3 March 2016
5578

Dear Ms Harras,
RE: 1 Lawson Square Redfern 2016

We refer to your email of 29 February 2016 wherein you request further consideration and a response to the review by the Department of Planning and Environment to the Section 96 drawings (Issue E) lodged with the department on the 26 February 2016. You have requested that we provide a response to concerns raised by the Department of Planning and Environment.

Department of Planning and Environment comments prepared by Natasha Harras

**DRAWING:**  
TYPICAL LEVEL 5-11 & LEVEL 12 PLANS  
**DRAWING No:**  
S96 - 1104  
**ISSUE:**  
5578  
E

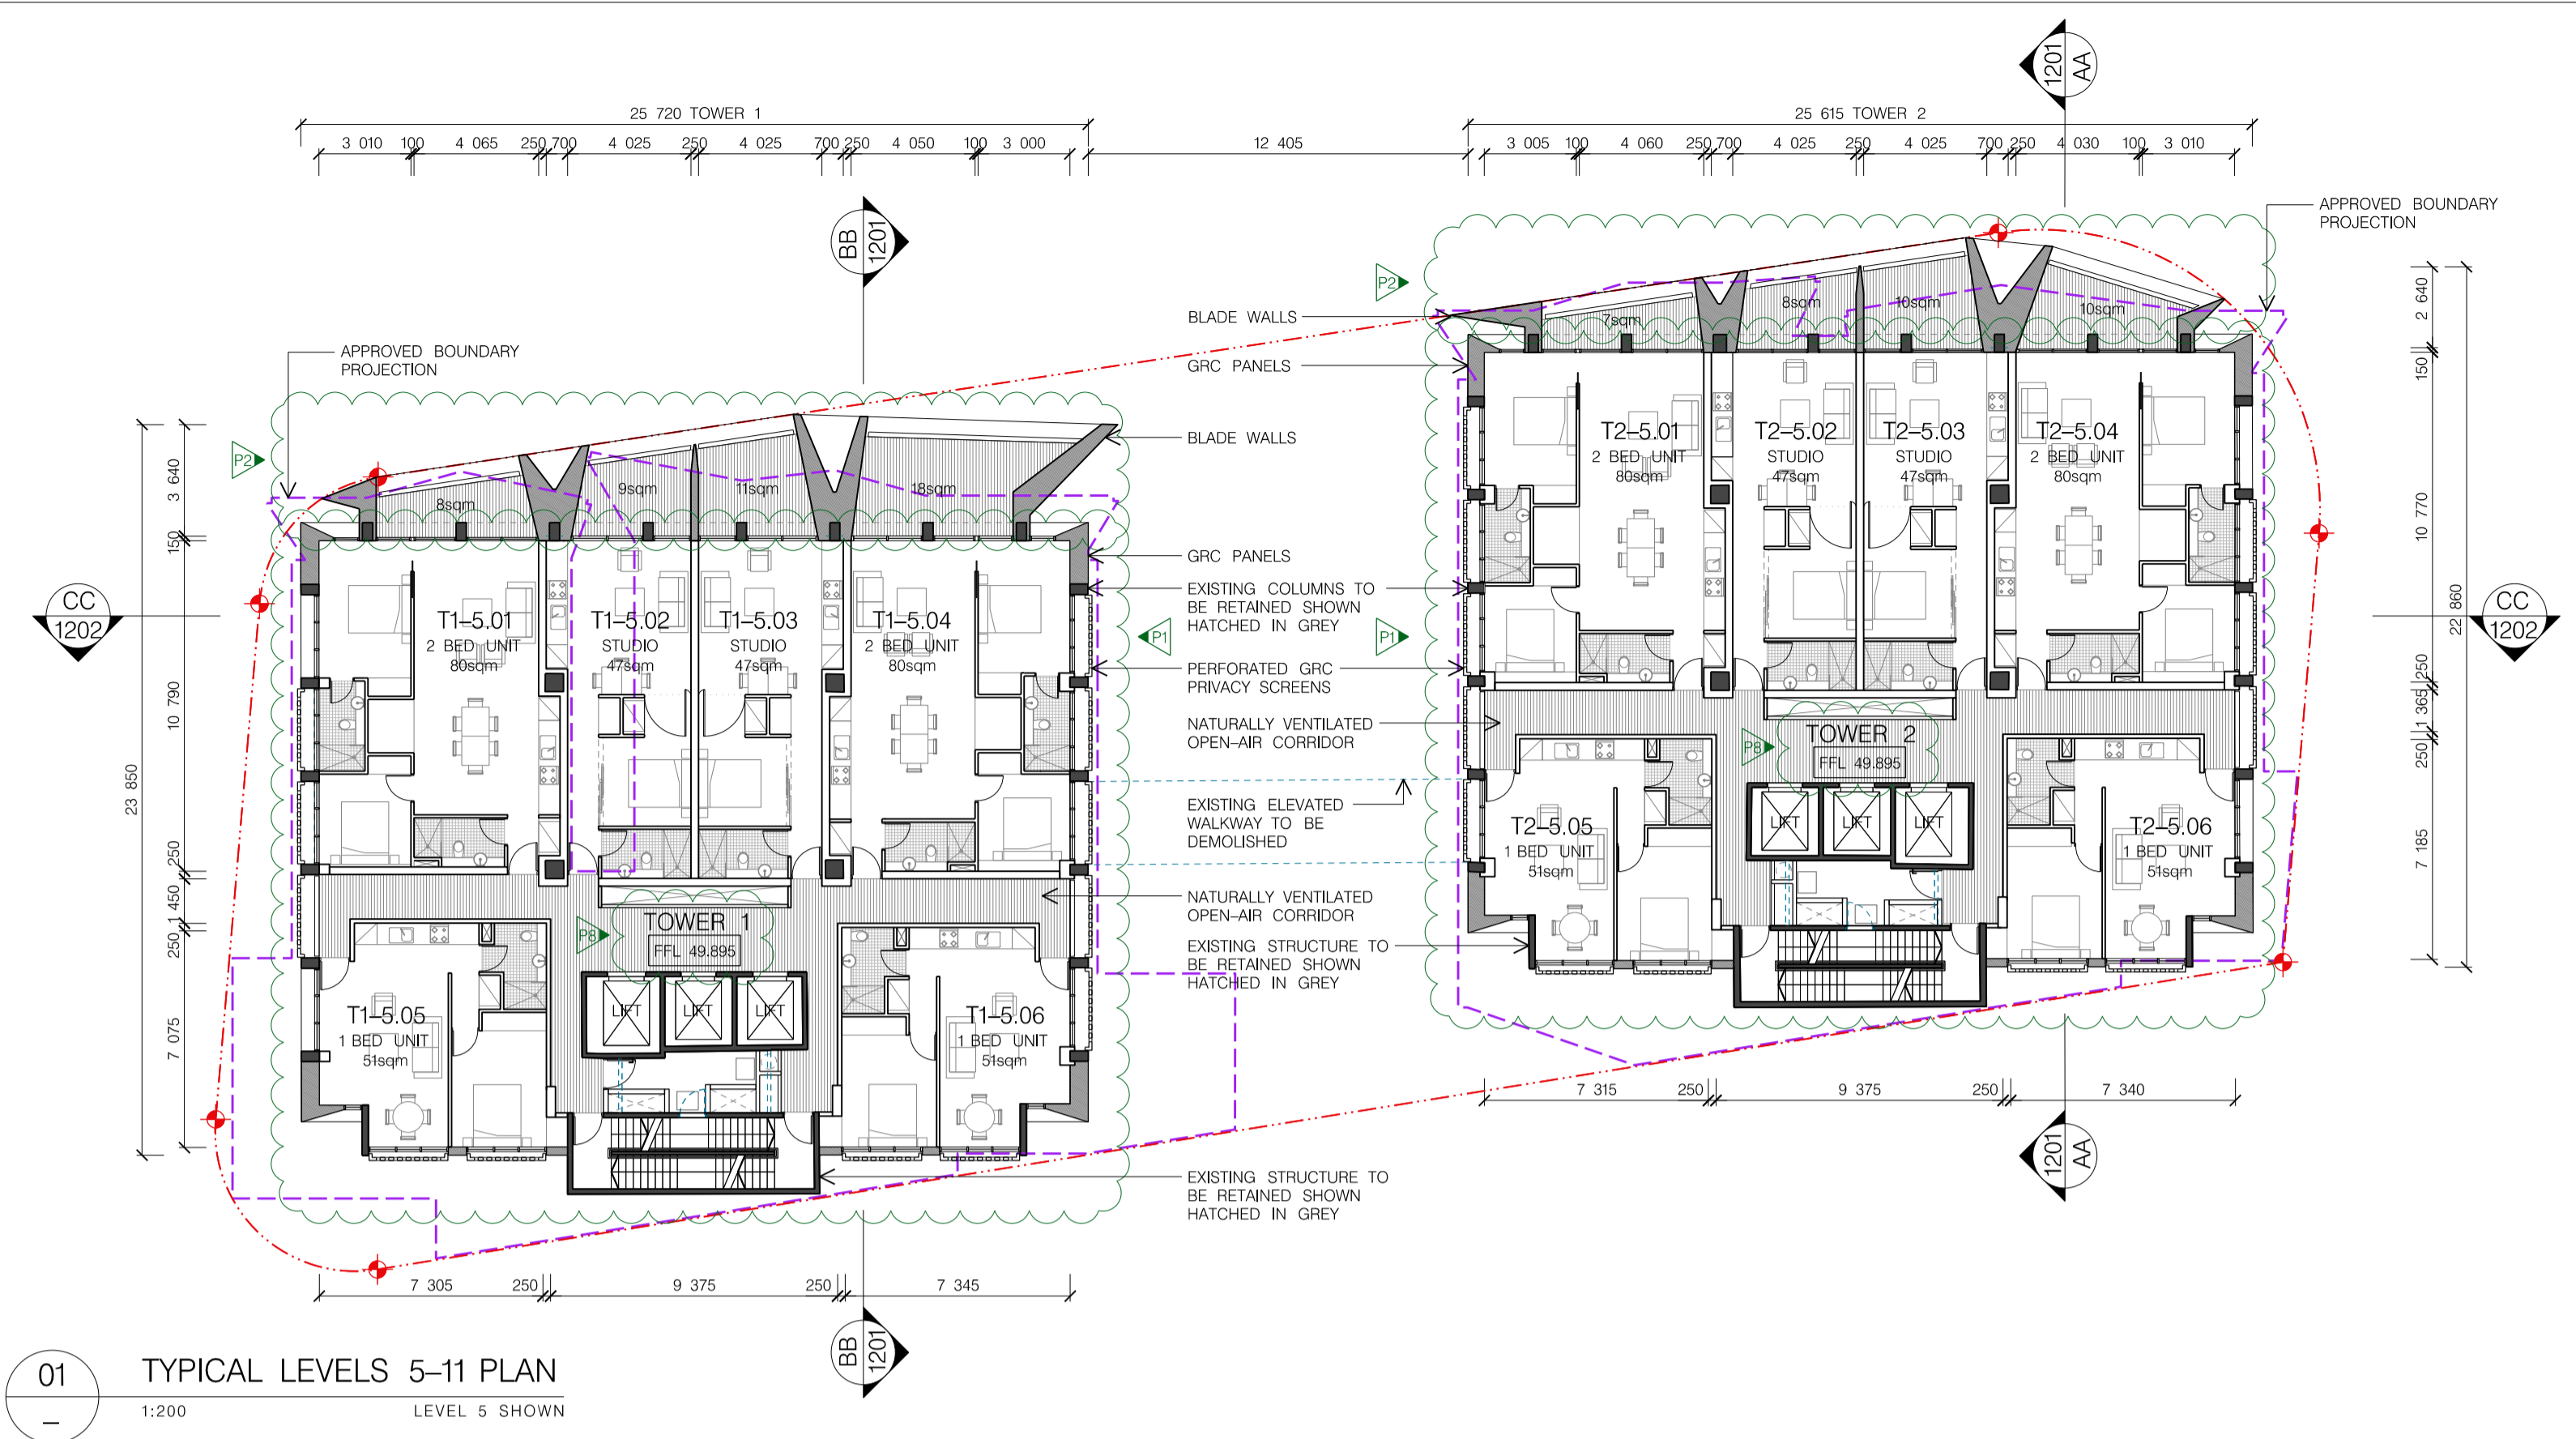
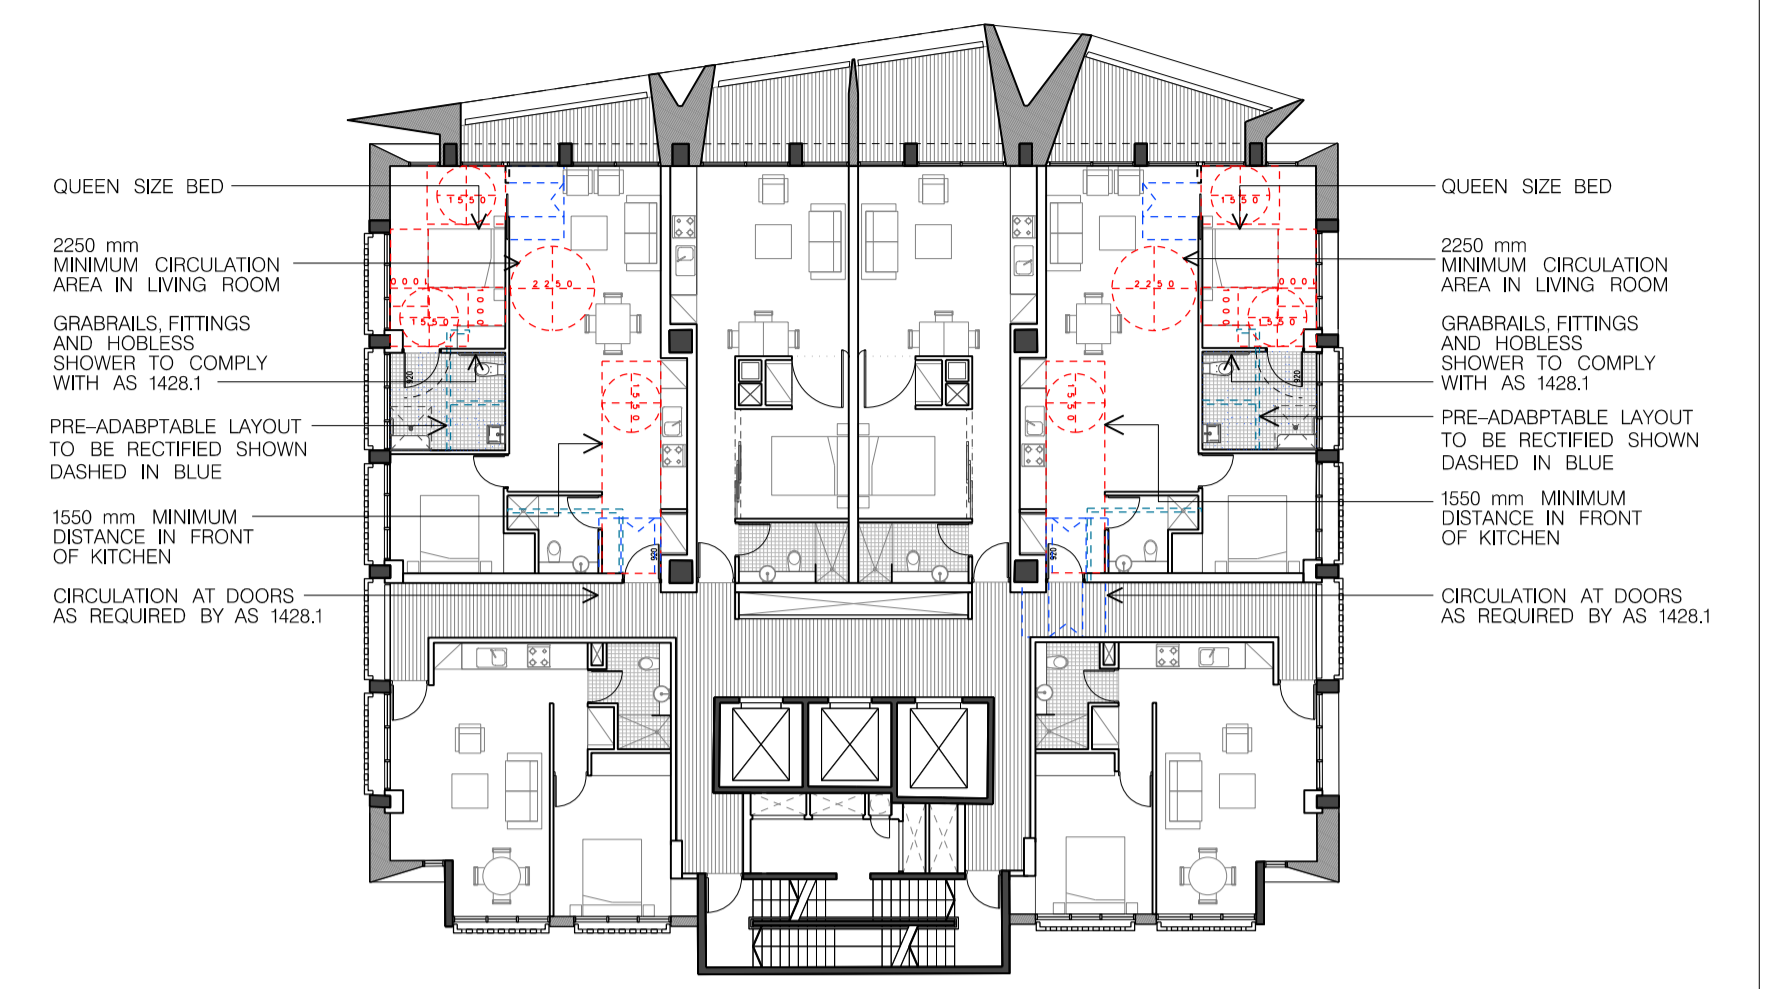
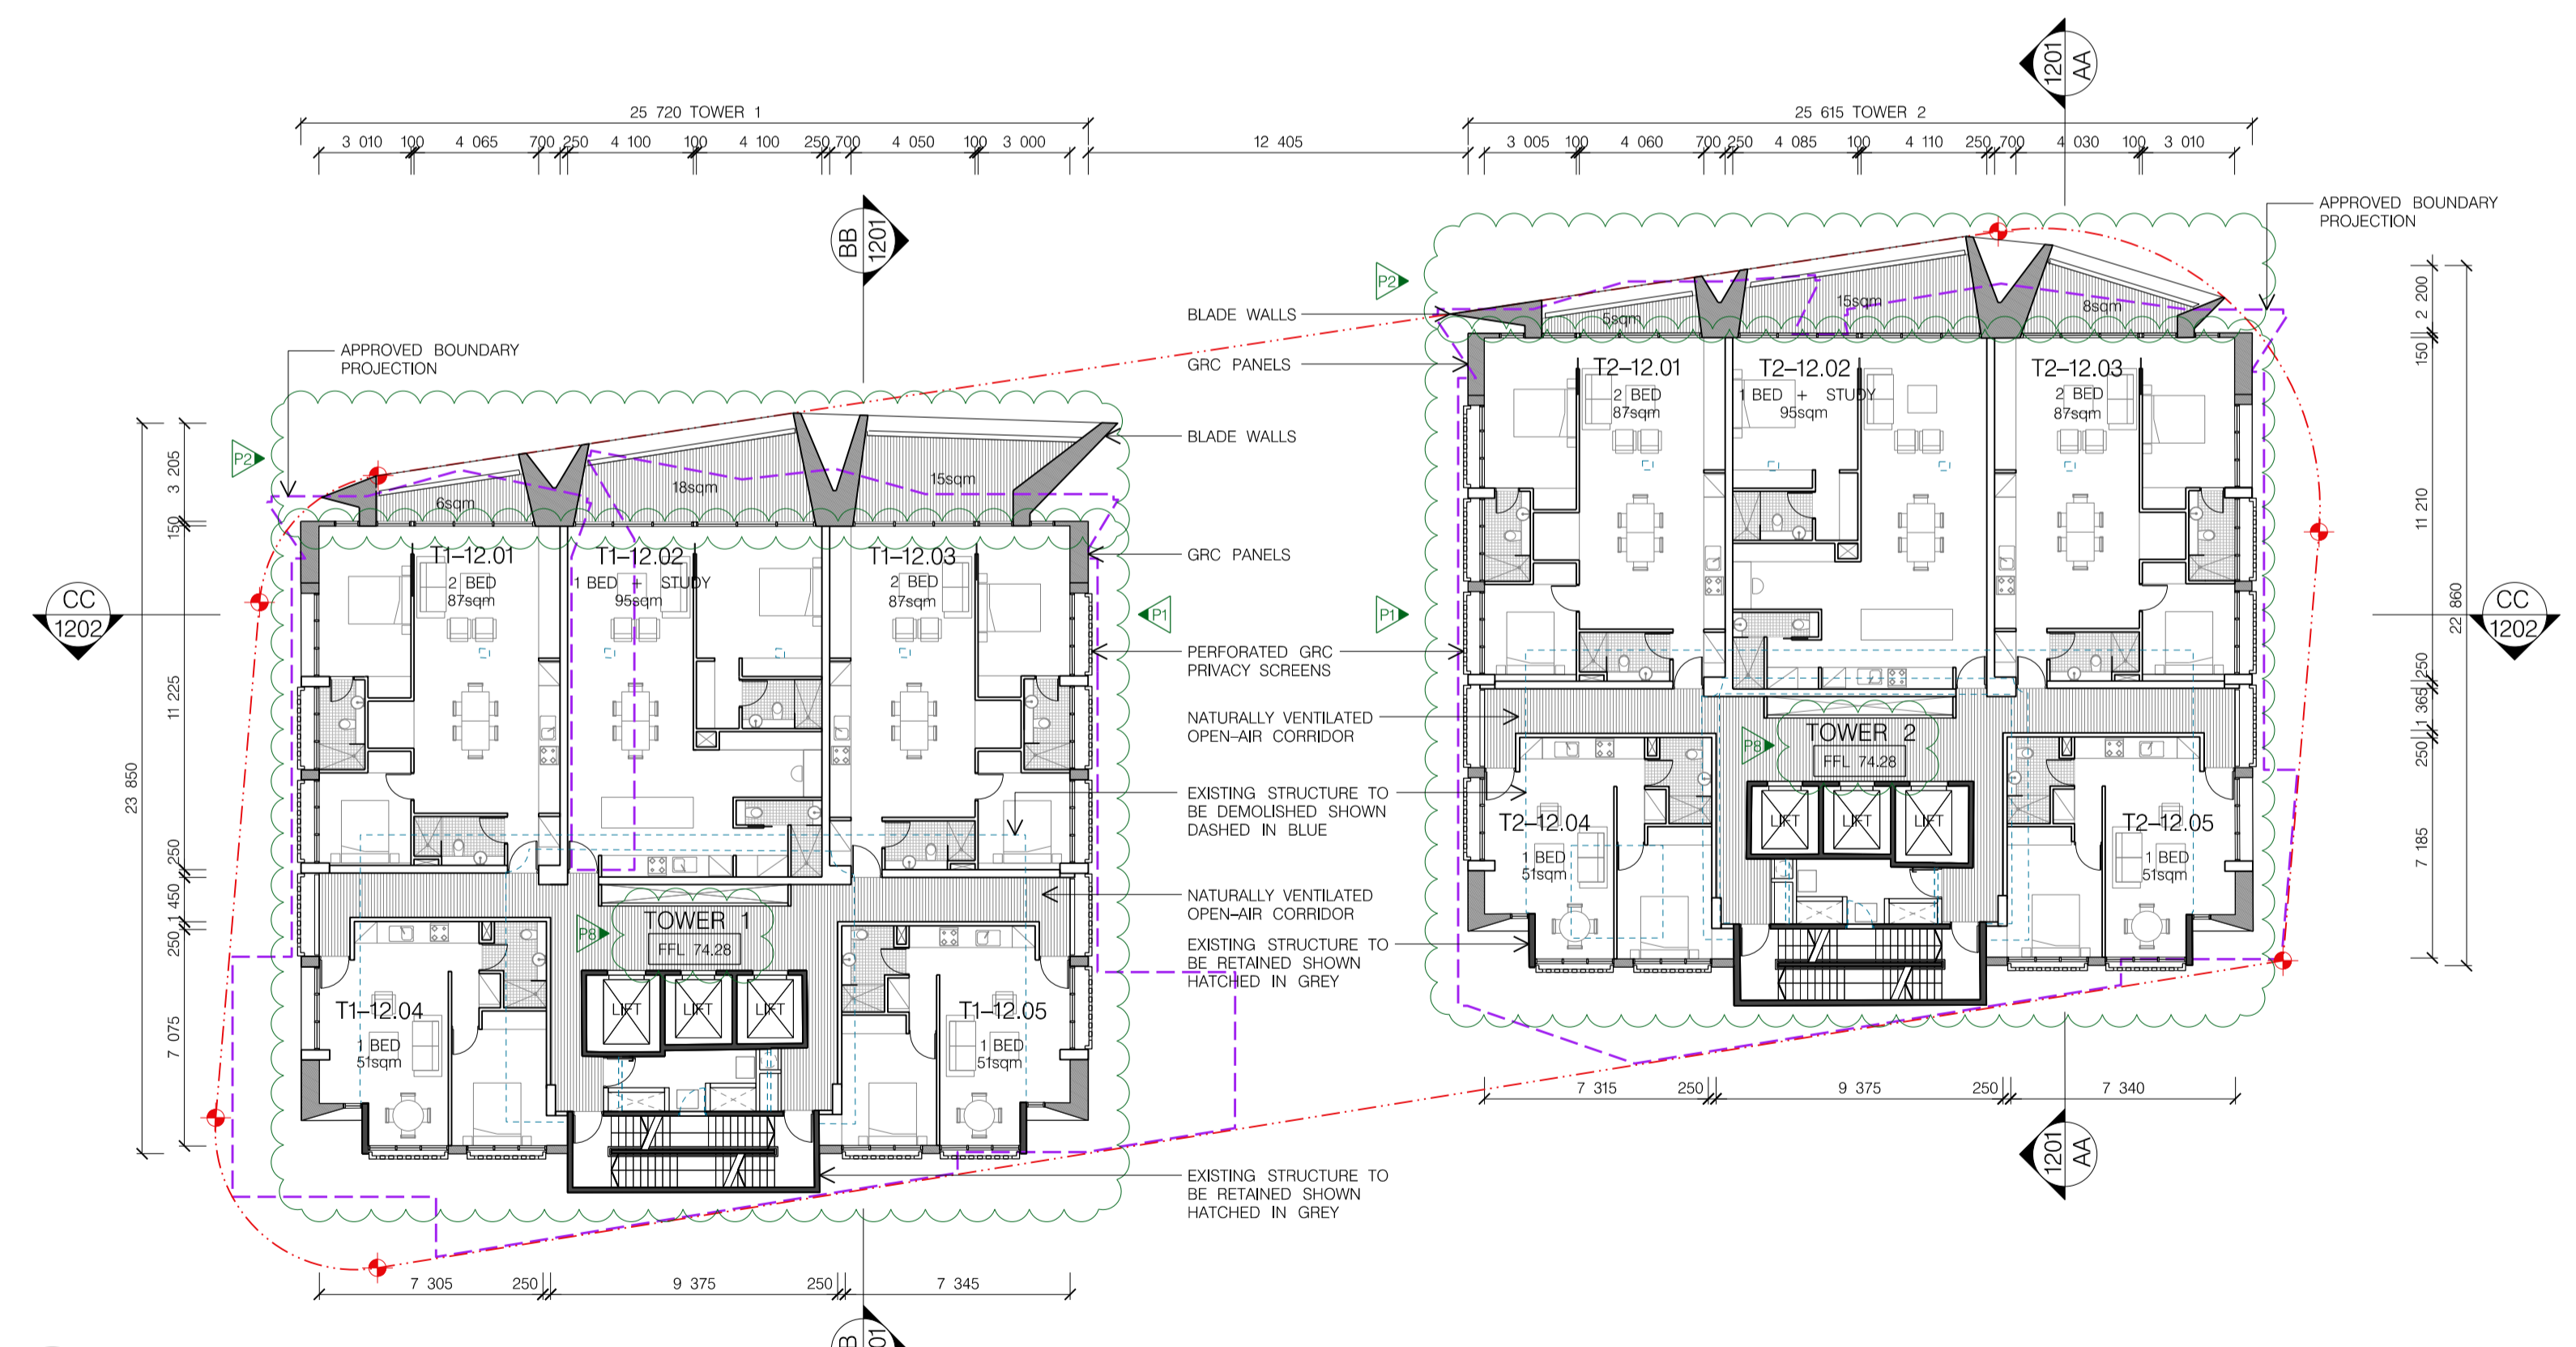
- 1. Concern is raised with the adequacy of the balconies for the two bedroom units on the northwest corner of tower 2 to provide adequate useable amenity space to service a two bedroom apartment. The arguments put forward in support of the smaller balconies are not accepted noting that:*
 - *At the upper levels, road or rail noise is not an issue;*
 - *The original wind impact assessment did not find any problems with wind to these balconies (only the south facing balconies); and*
 - *The balconies as approved are of an acceptable size.*

Response: The subject 2 bedroom apartments to the northwest corner of both towers have been amended to provide 10sqm of balcony space. The balconies now satisfy the minimum requirements under the Apartment Design Guide. Please refer to the revised S96 drawings for further detail.
